DCO Submission

Appendix 3.3: Summary of Stage 1 Non-Statutory consultation comments

Document 6.3C

Oxfordshire Railfreight Limited

**APPENDIX B – INDIVIDUAL SITE AREAS**

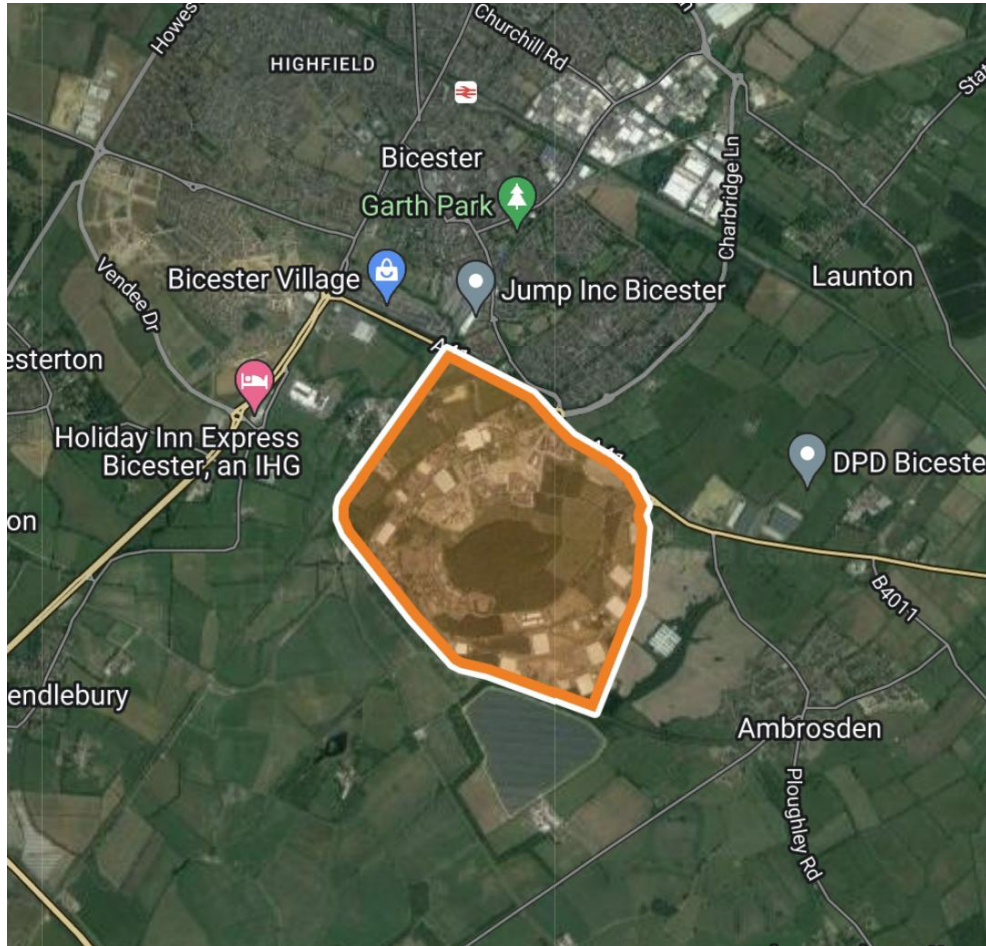
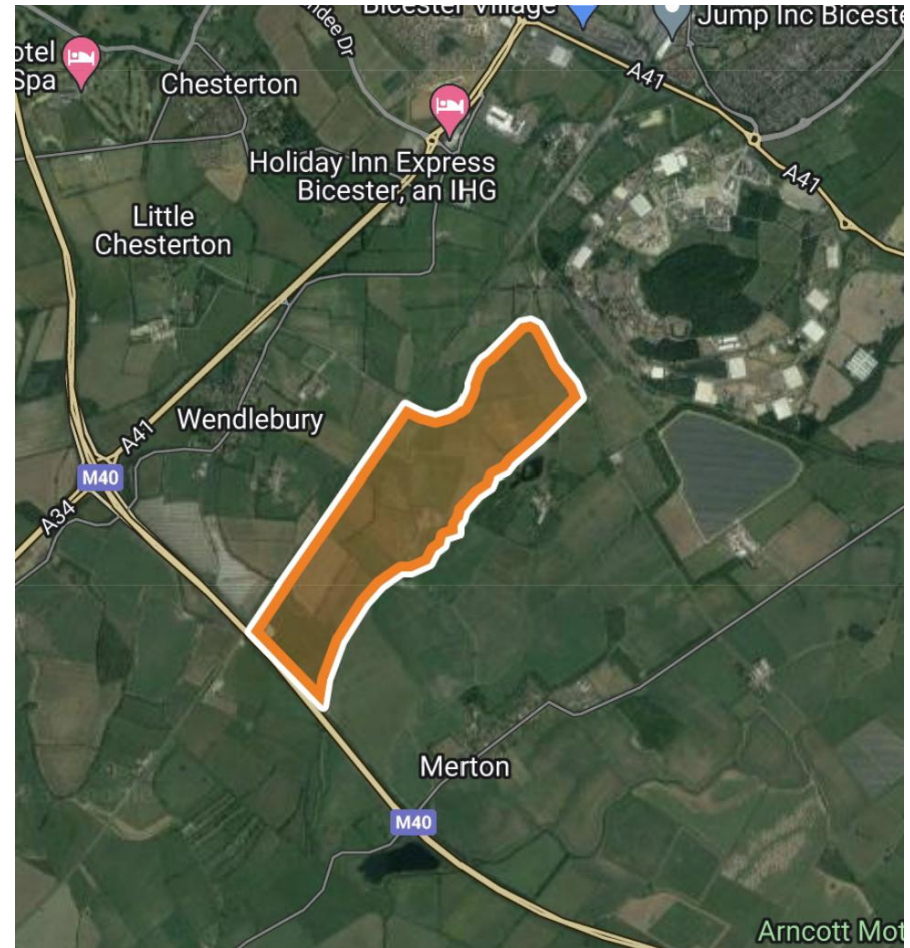
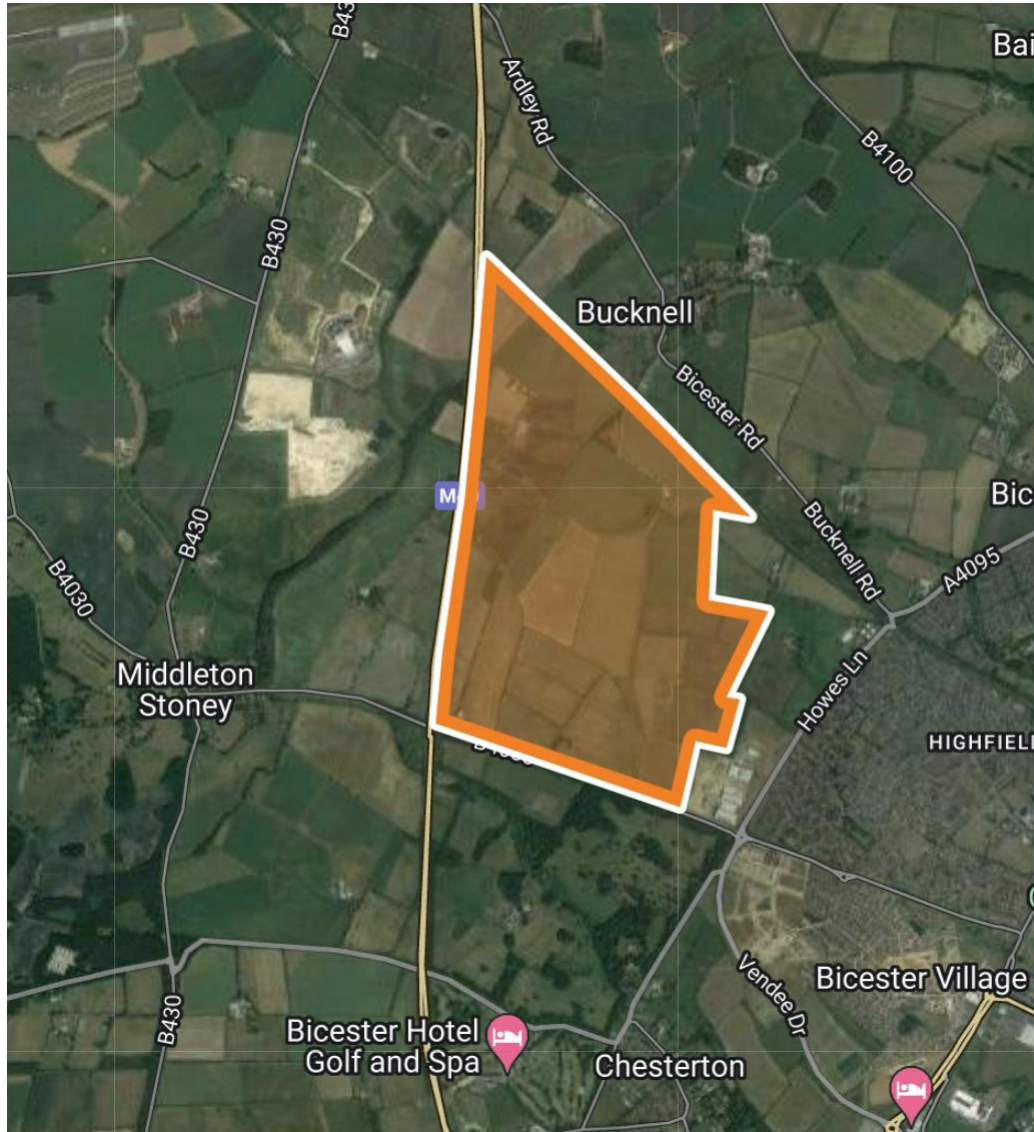
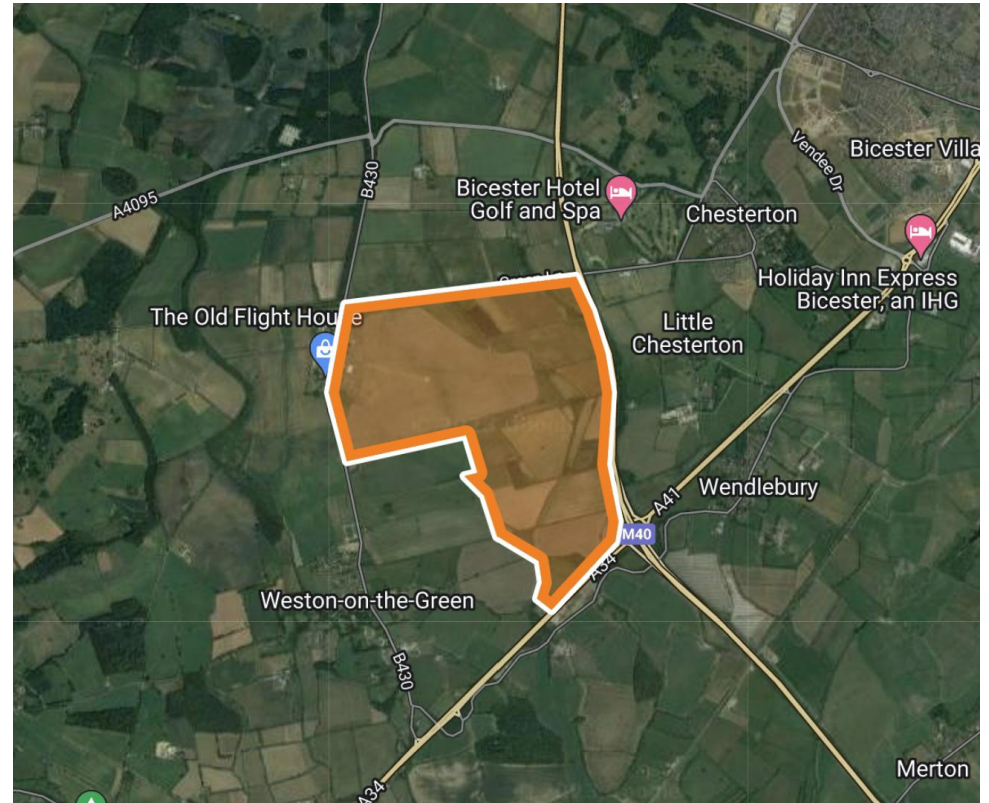
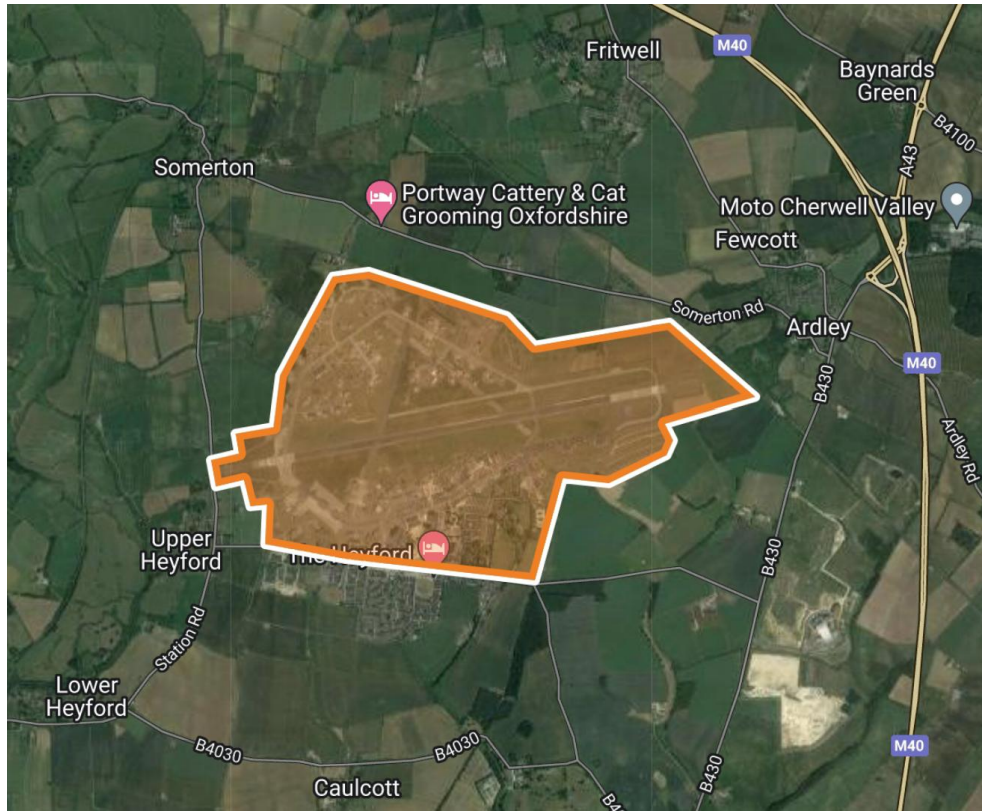
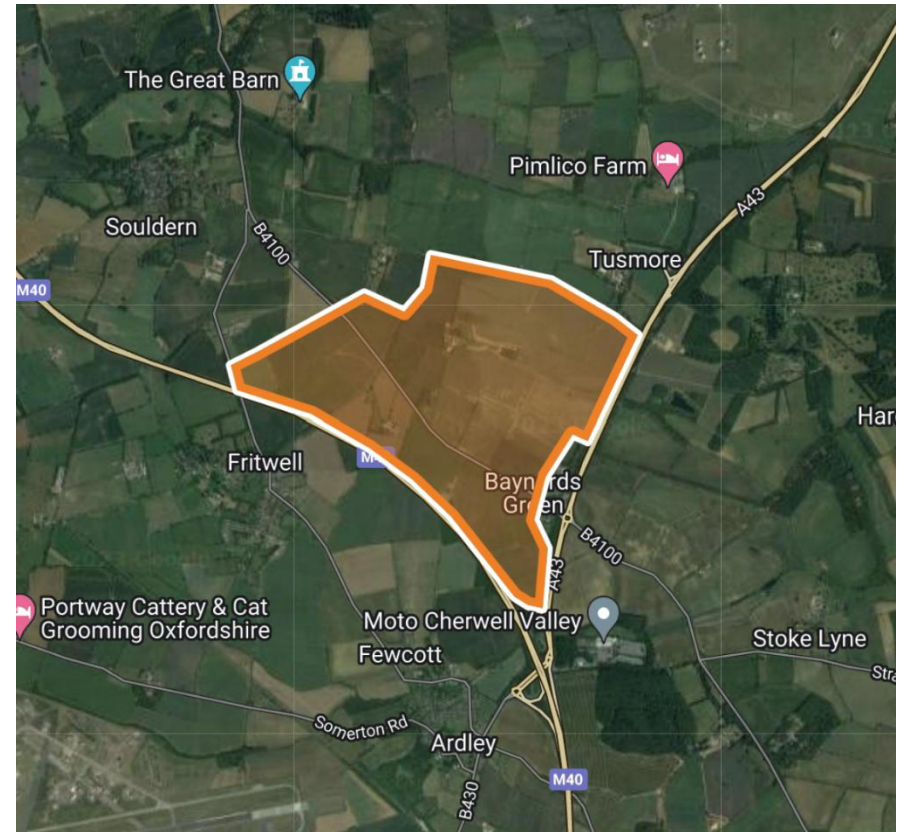
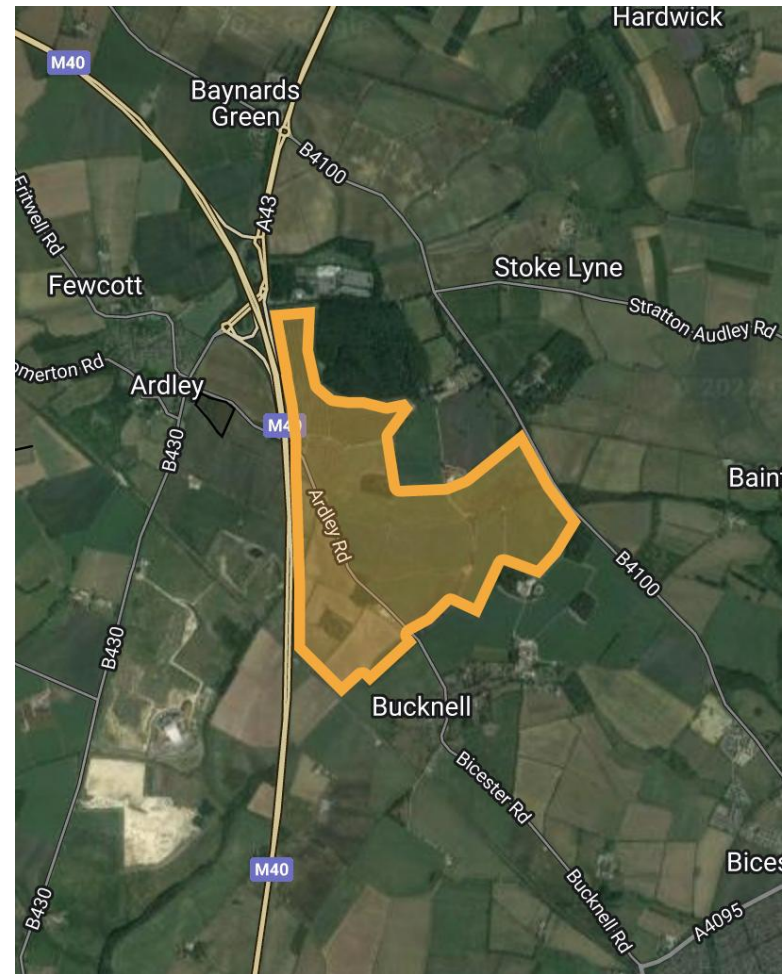
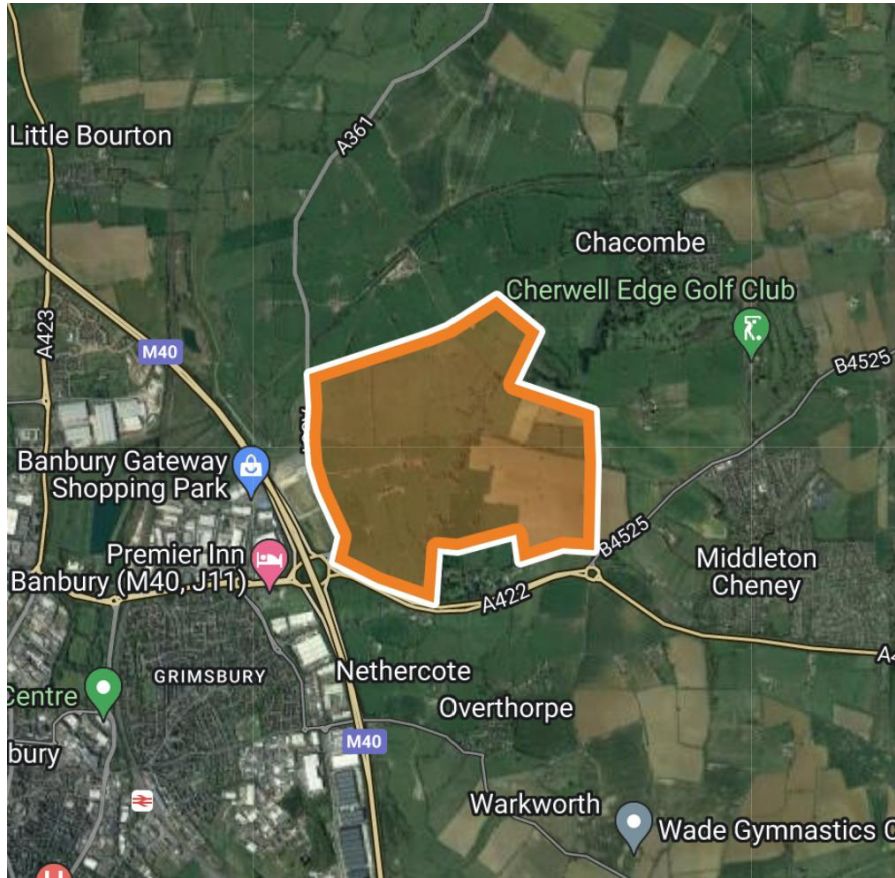
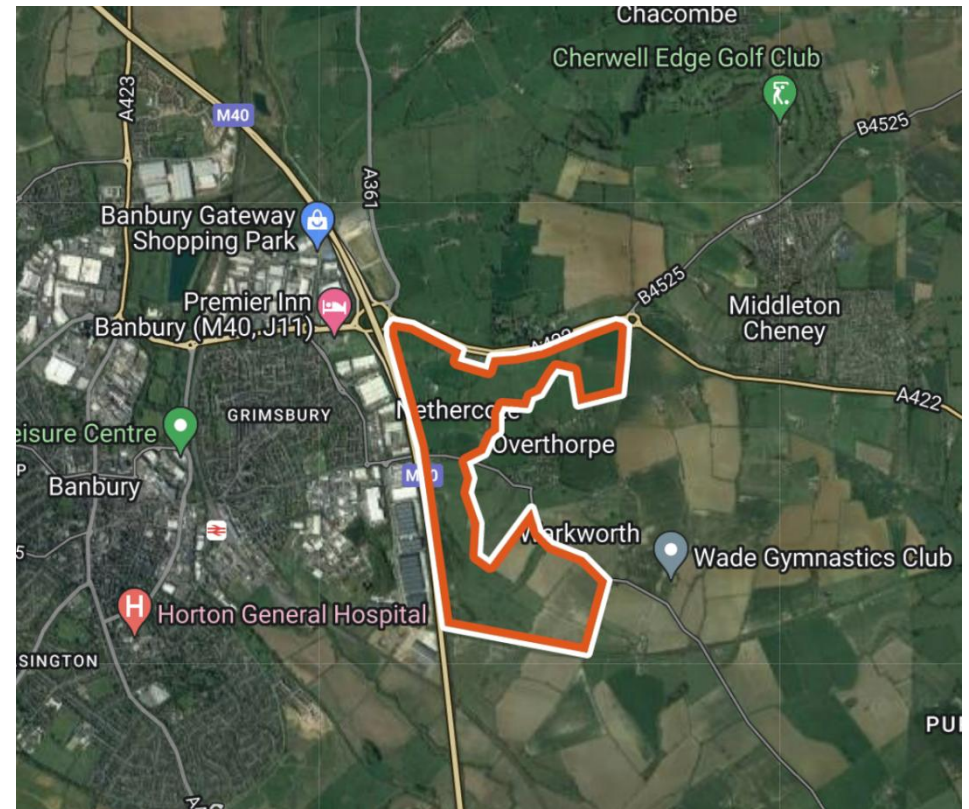
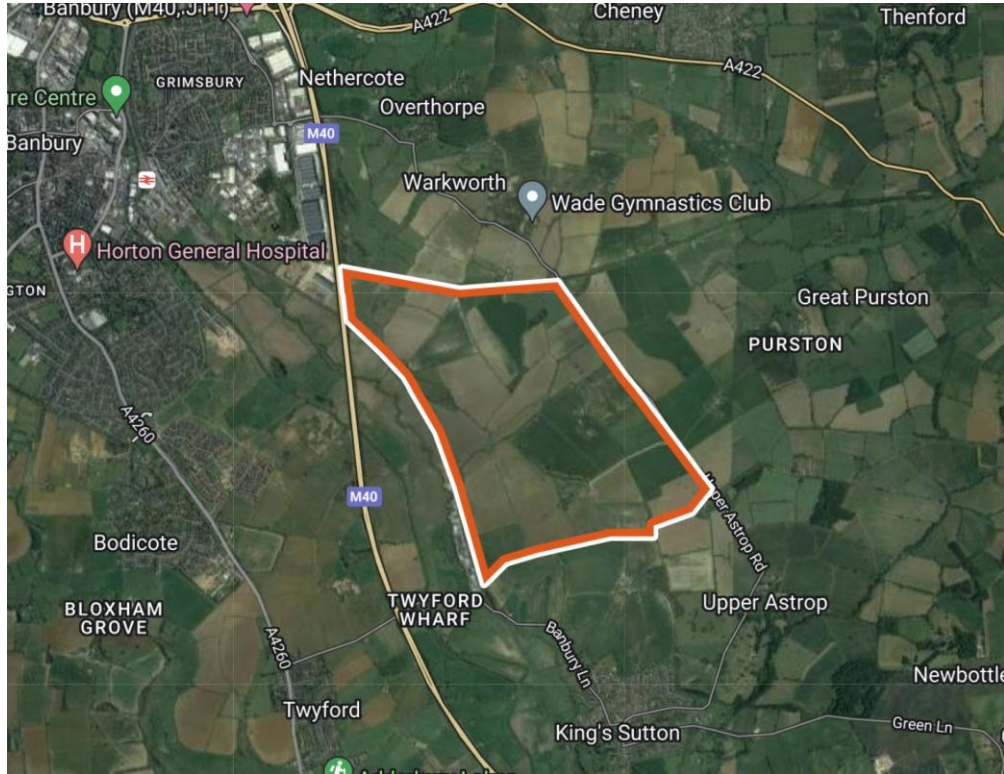
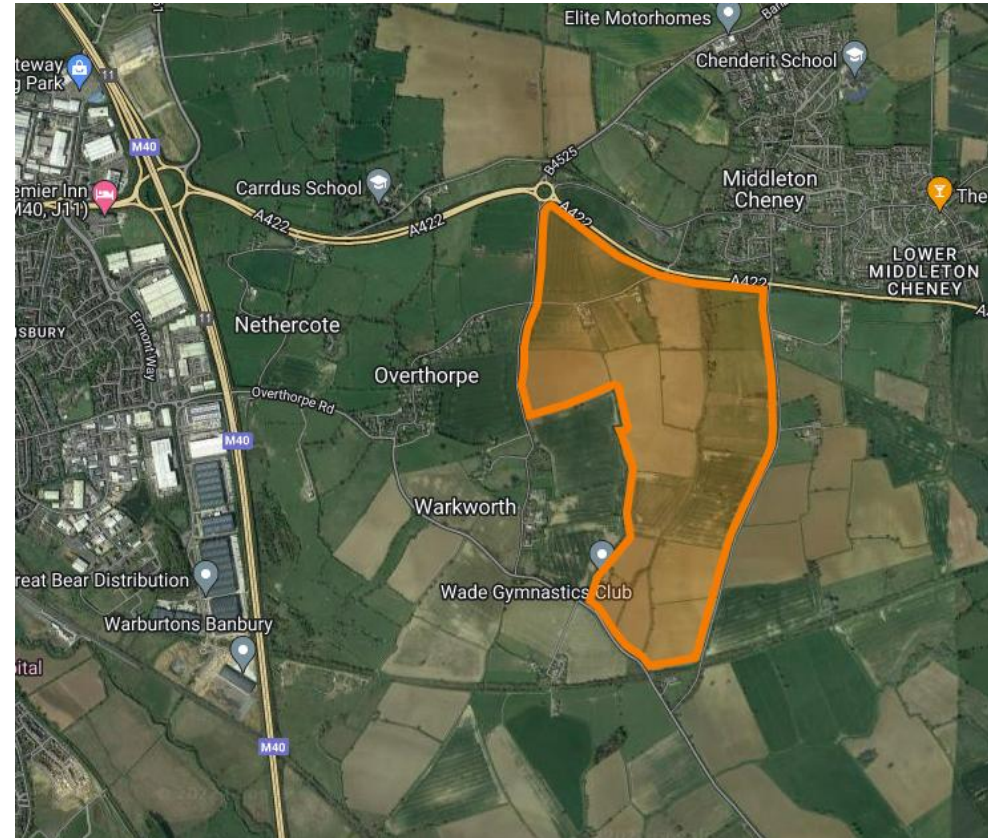
Paragraph reference	Subject	Response / Action Taken
The need for development at this location		
21	OCC raise concern that the rail freight terminal use cannot be enforced, and that the site could become a large logistics park with the added benefit of freight handling. This would in turn mean the environmental benefits of the development are overstated.	The DCO is drafted in such a way as to secure the delivery of the rail terminal an early action, and to limit occupation of warehousing beyond a defined level (2.5million sq. ft).until the terminal is complete and available for use. As proposed, the site could not be delivered without a rail terminal.
22	OCC have not seen much evidence that the location is an optimal place for an SRFI.	The Planning Statement underlines the compliance with the requirements of the NPS which sets criteria for SRFIs, and their locations, including with regard to the strategic road and rail networks. The ES establishes the suitability of the site in environmental terms. The Alternative Sites Assessment ES Appendix 2.4 identifies no more suitable (or equally suitable) sites in a wide search area.

CDC require a comparative assessment of potential locations for the proposed SRFI with a proportionate comparison of sustainability credentials and impacts.	The Alternative Sites Assessment appended to the ES provides a comparative assessment of potentially suitable alternative sites.
CDC agree with OCC that a 10% modal shift target for single occupancy car modal share is insufficiently ambitious.	Travel Plan targets were discussed and agreed with the TWG and an ambitious but achievable target to reduce SOV trips by 26% is agreed. This aligns with the OCC LTCP5 target to remove 1 out of every 4 current car trips in Oxfordshire by 2030.
CDC note that deliverable proposals for non-car based connectivity to Bicester will be needed. The	The STS that is appended to the TA along with the Framework Travel Plan (ES Appendix 3.2) describe the hard infrastructure and softer
